EPC STORMWATER REVIEW COMMENTS IN ORANGE BOXES WITH BLACK TEXT

OVERALL ALTERNATIVE LANDSCAPE PLAN

The Shire At Old Ranch
Howells & Old Ranch Road
Colorado Springs, CO

**LS 3**

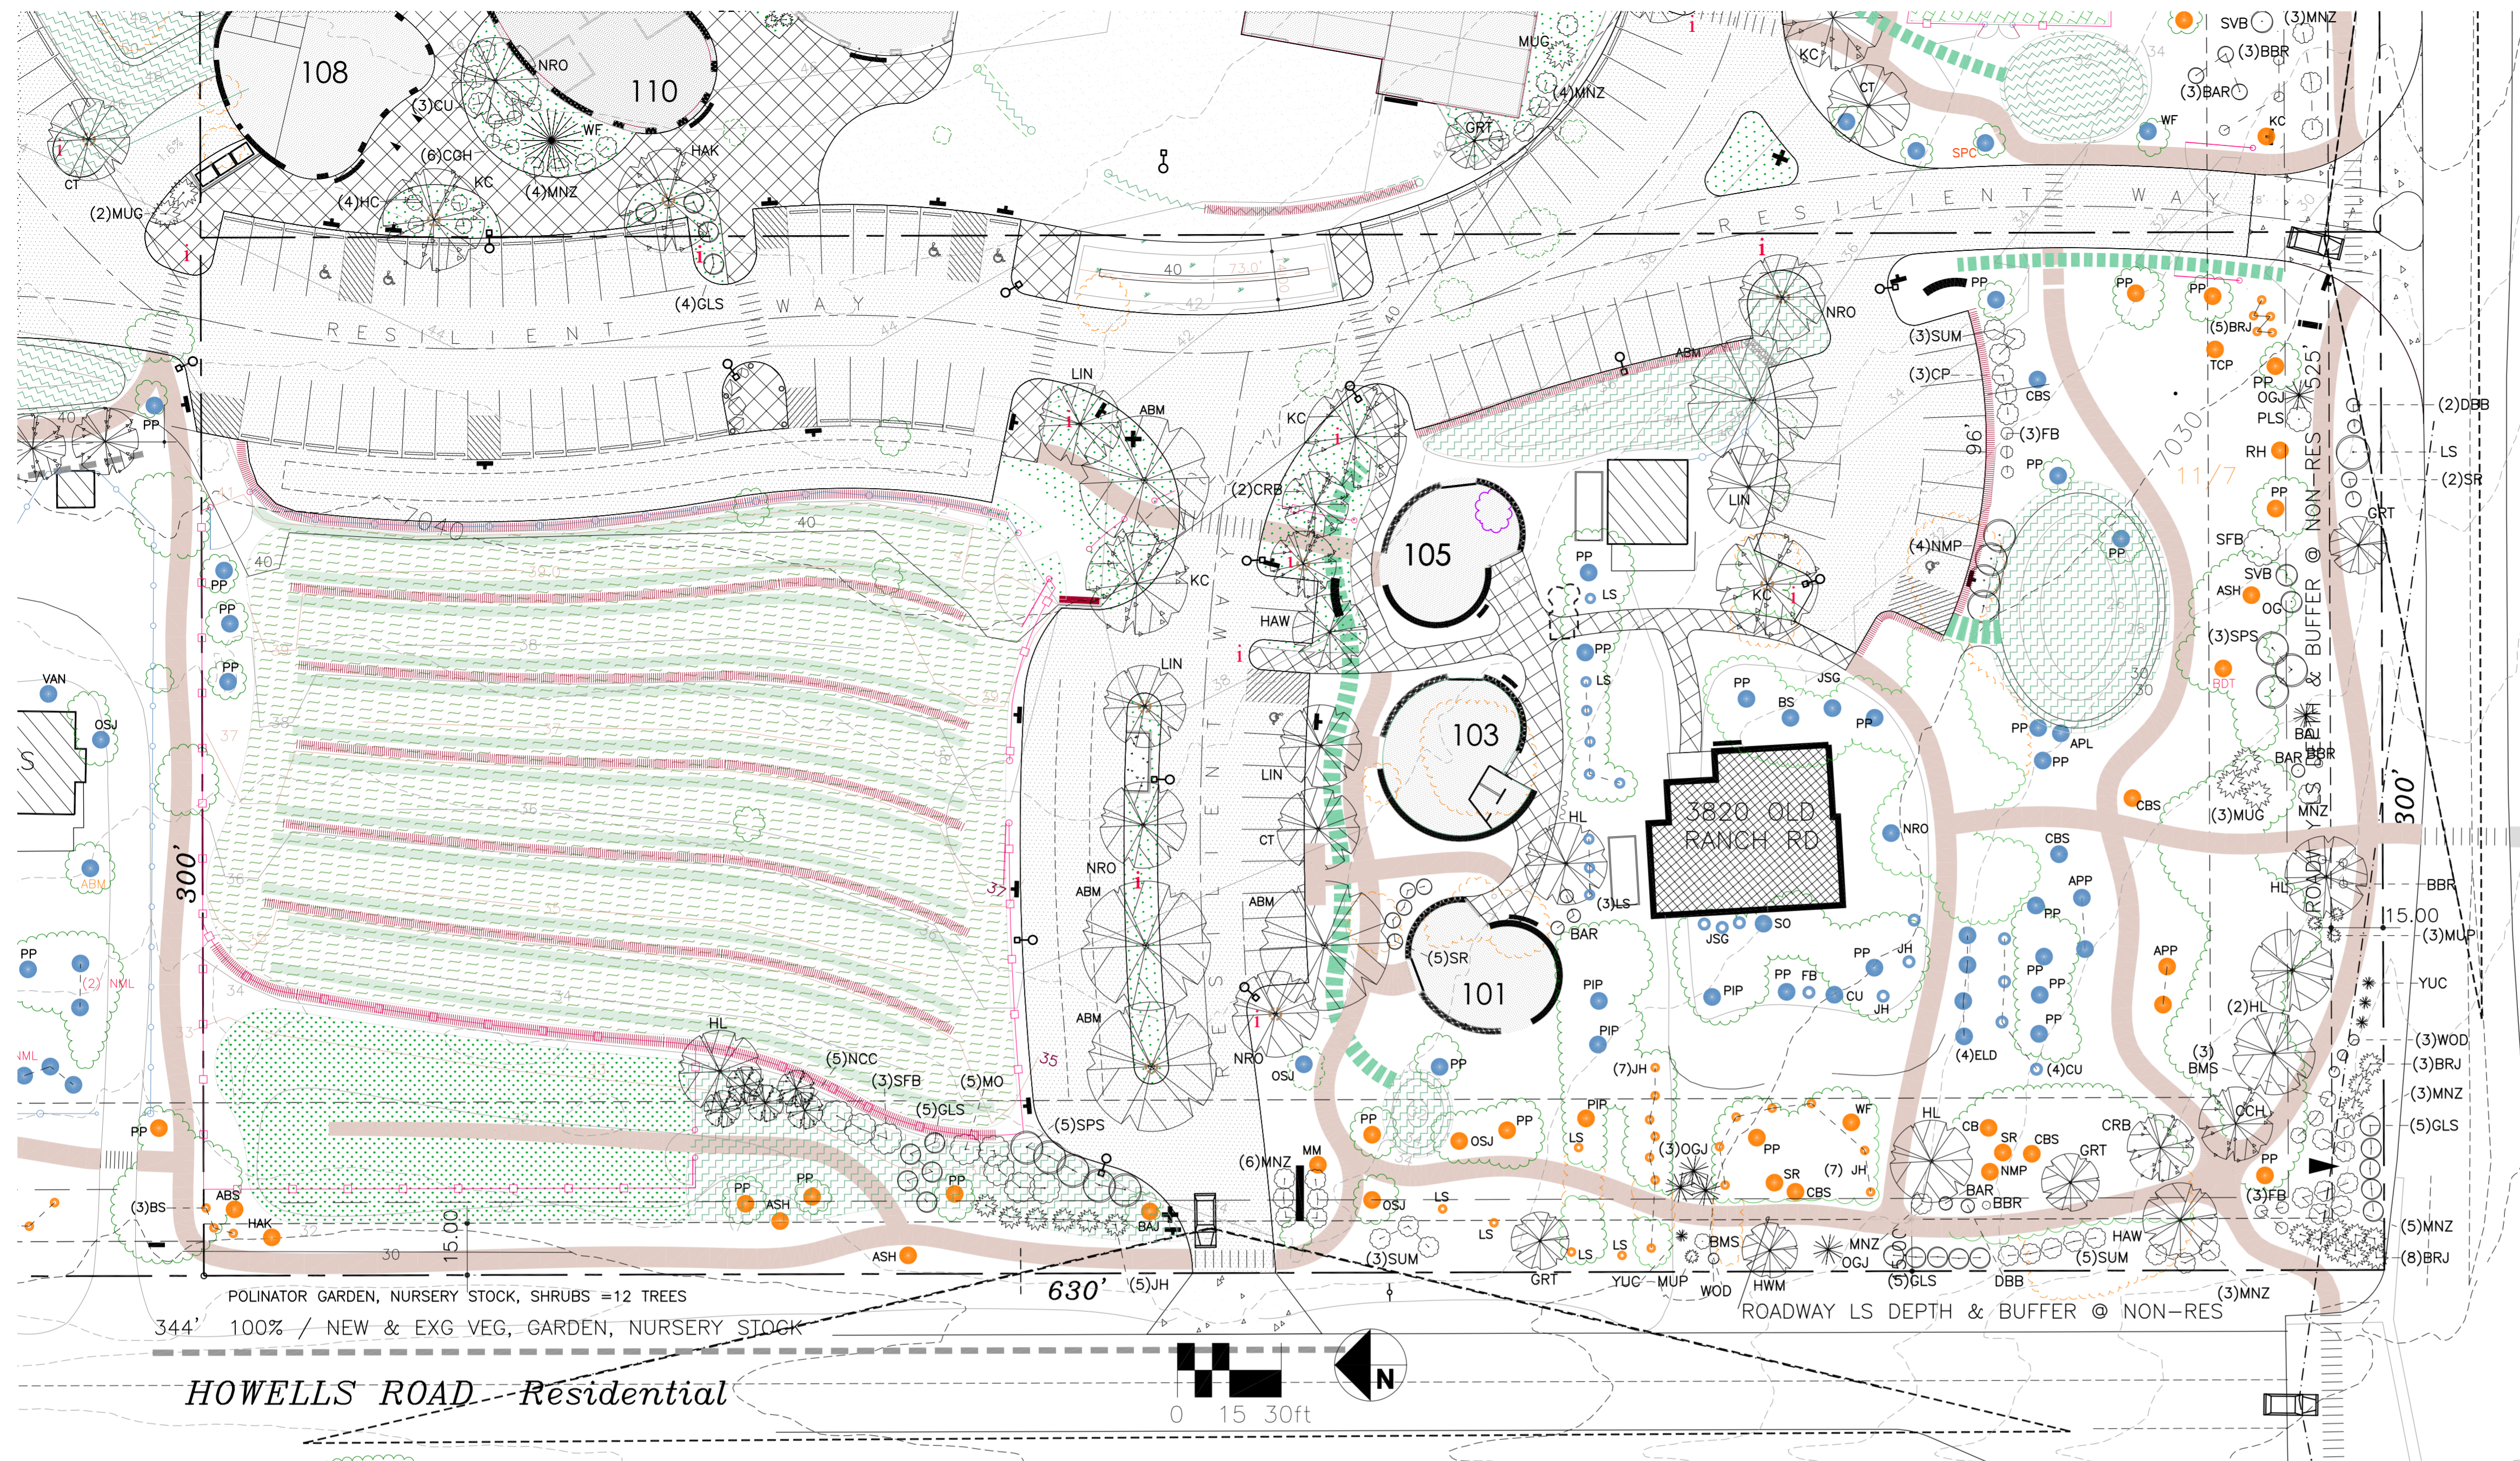
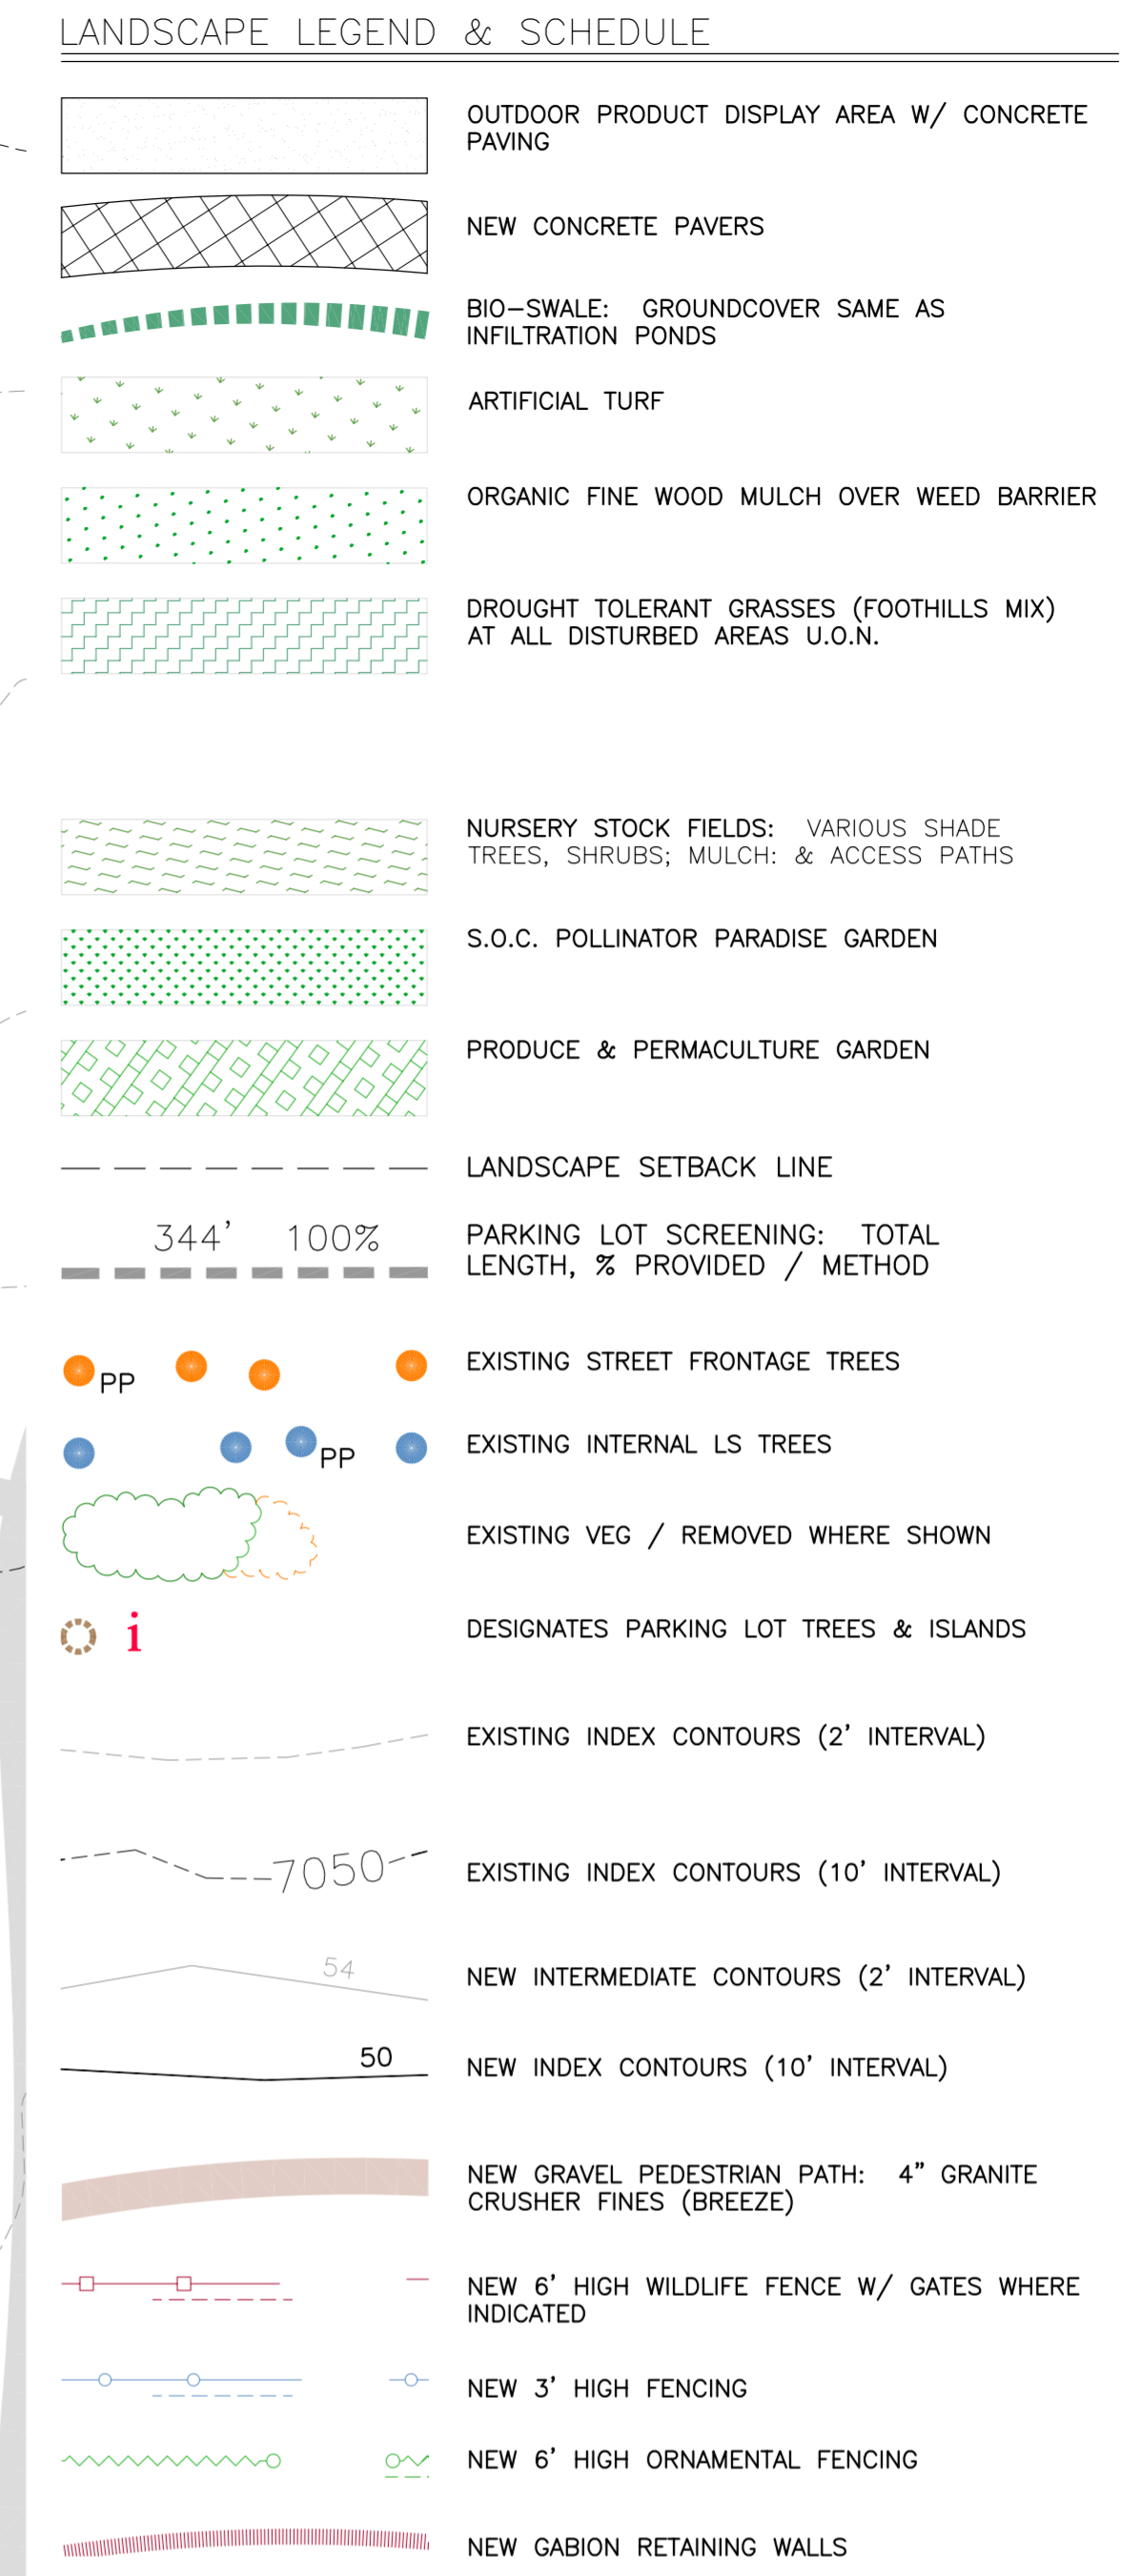
This type of tree is not recommended per the landscape code, please consider planting a different species, what is existing is fine
